Sea Link

**Document 9.1: Applicant's Response to S51 Advice**

**Planning Inspectorate Reference: EN020026**

**Version: A**  
**June 2025**

# 2.7.1 Access, Rights of Way and Public Rights of Navigation Plans - Suffolk

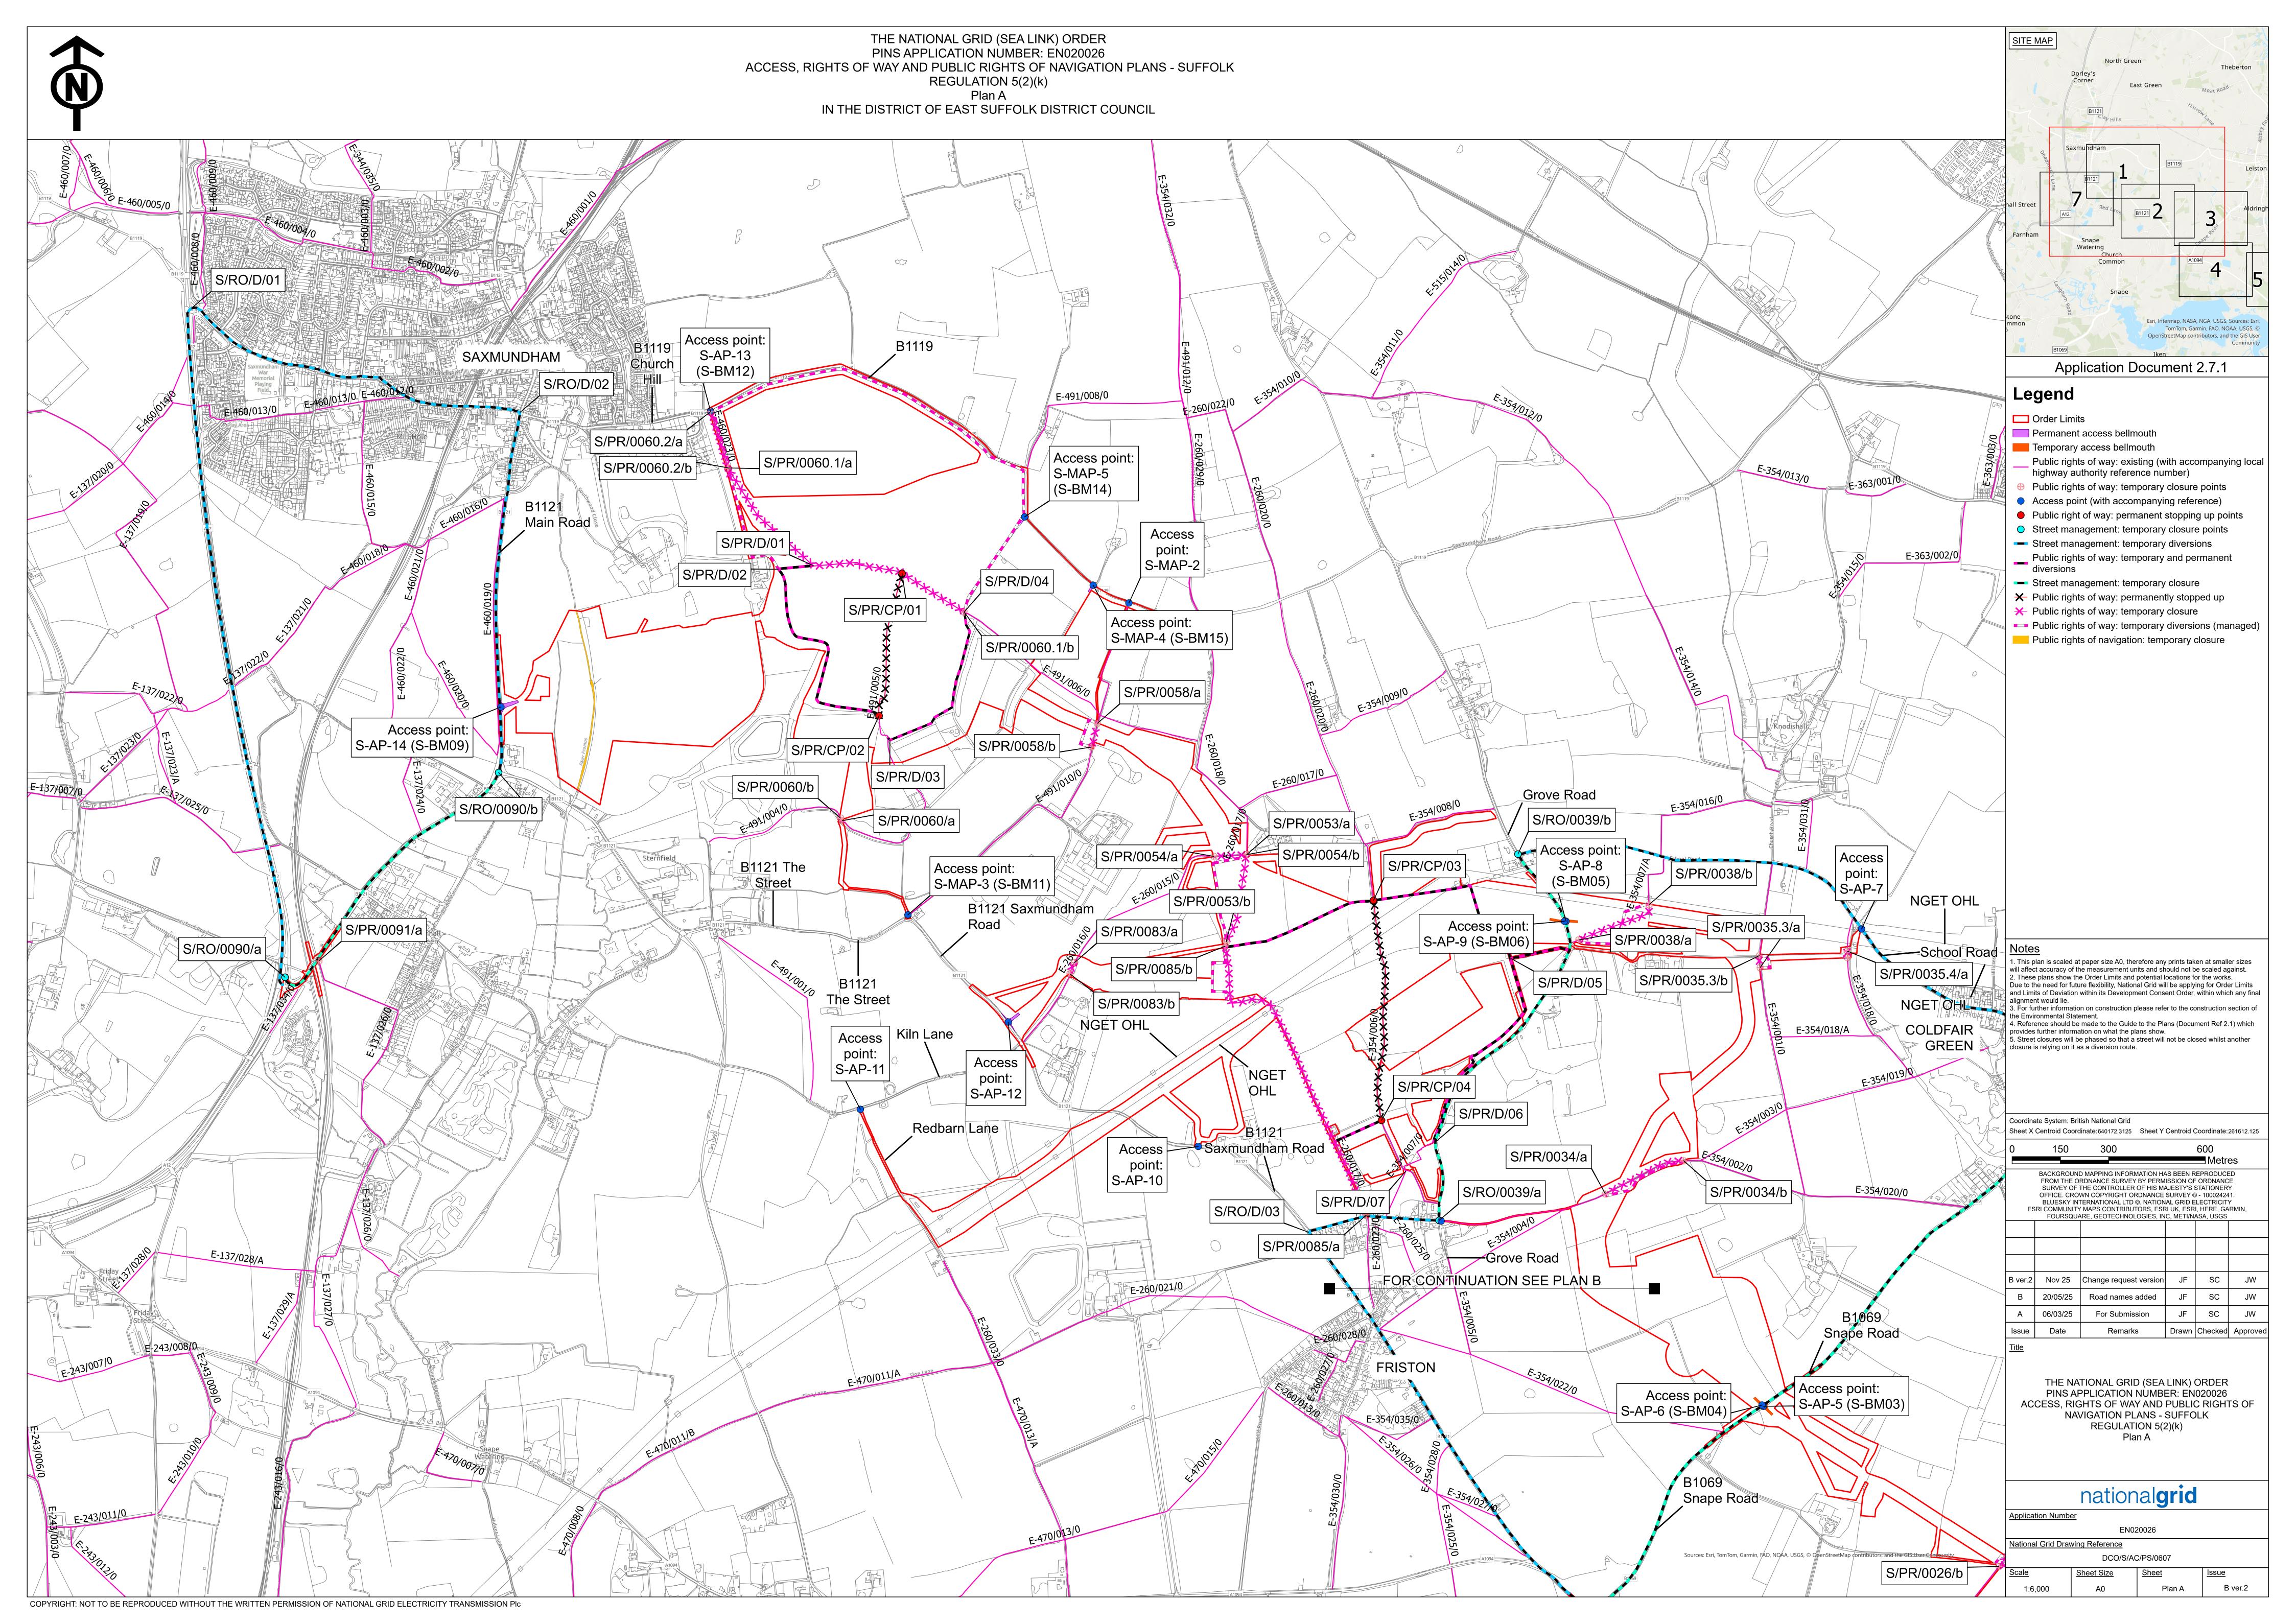
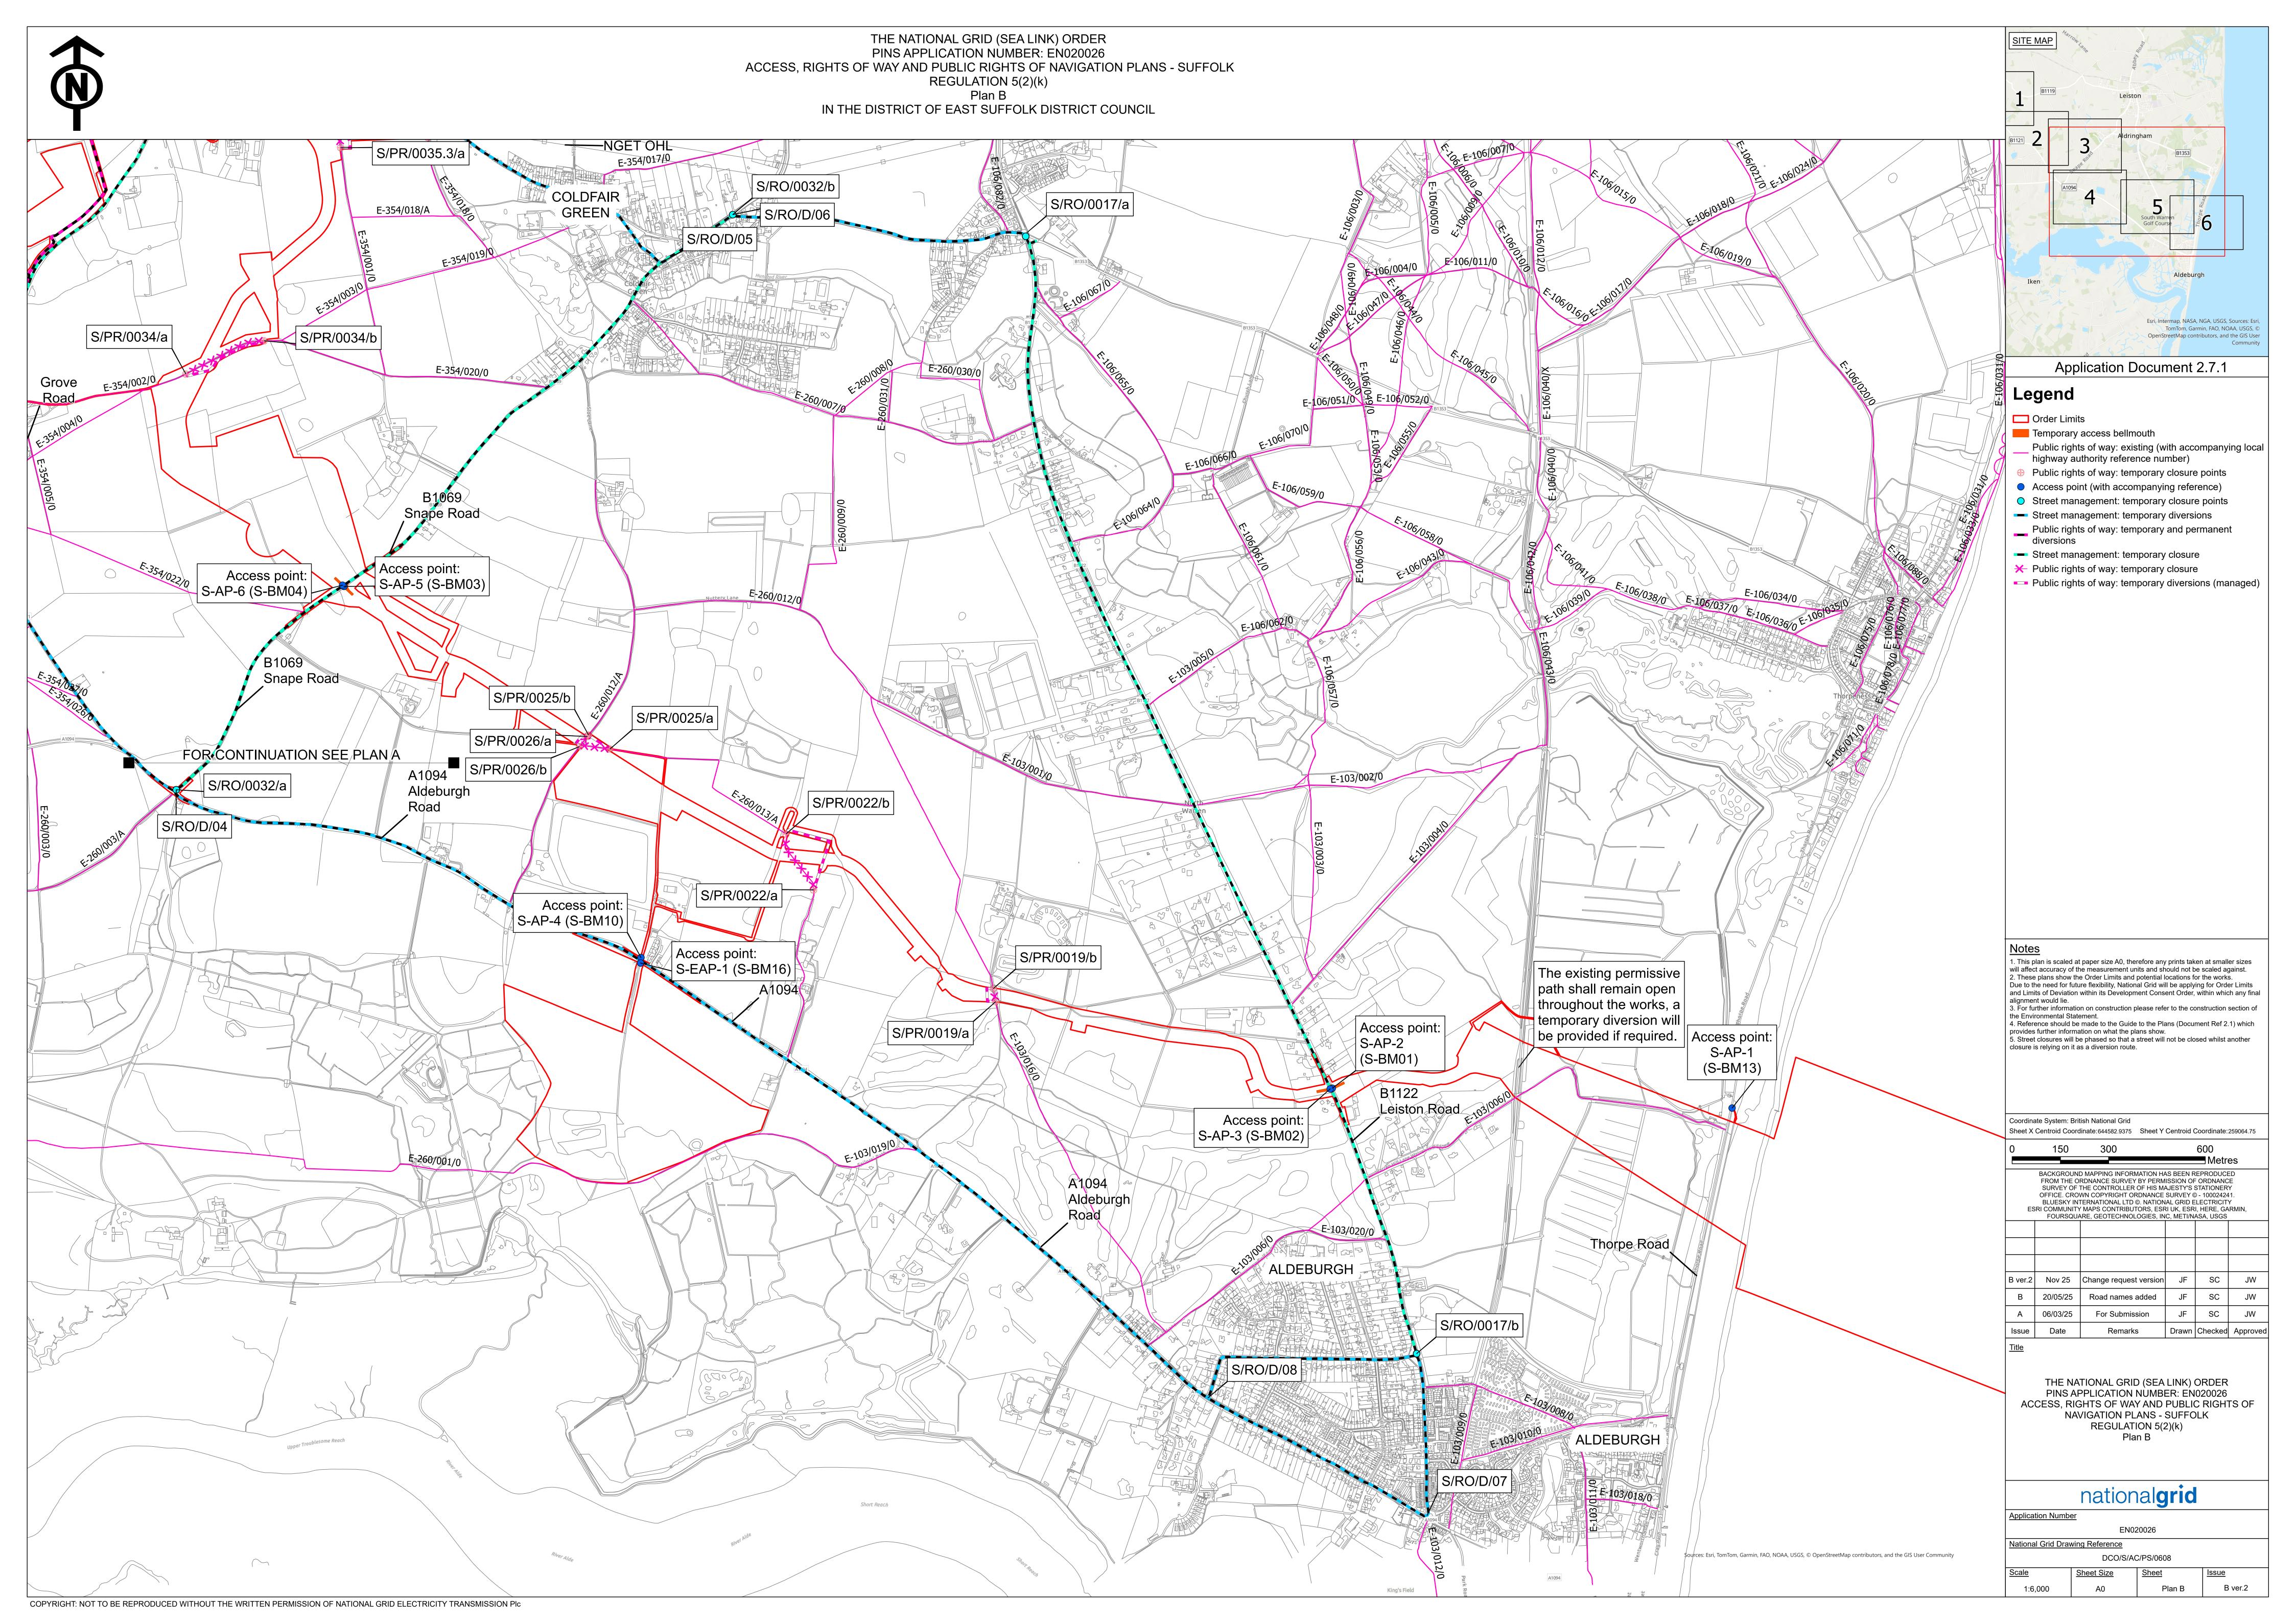
2.7.1 Access, Rights of Way and Public Rights of Navigation Plans - Suffolk	<p>Some of the road names are not marked in the plans as mentioned in the Schedule 5 – Streets subject to street works. For example</p> <p>– Leiston Road is listed in Schedule 5 to be on the Sheet 5 of Plans but is not marked on the plan."</p>	The applicant has updated Access, Rights of Way and Public Rights of Navigation Plans (Doc 2.7) in response to the s51 advice, which is submitted alongside this response.
Advice from Box 30 of the s55 Checklist	Various typographical errors	The applicant provided updated documents responding to various typographical errors found in the advice from Box 30 of the s55 checklist.
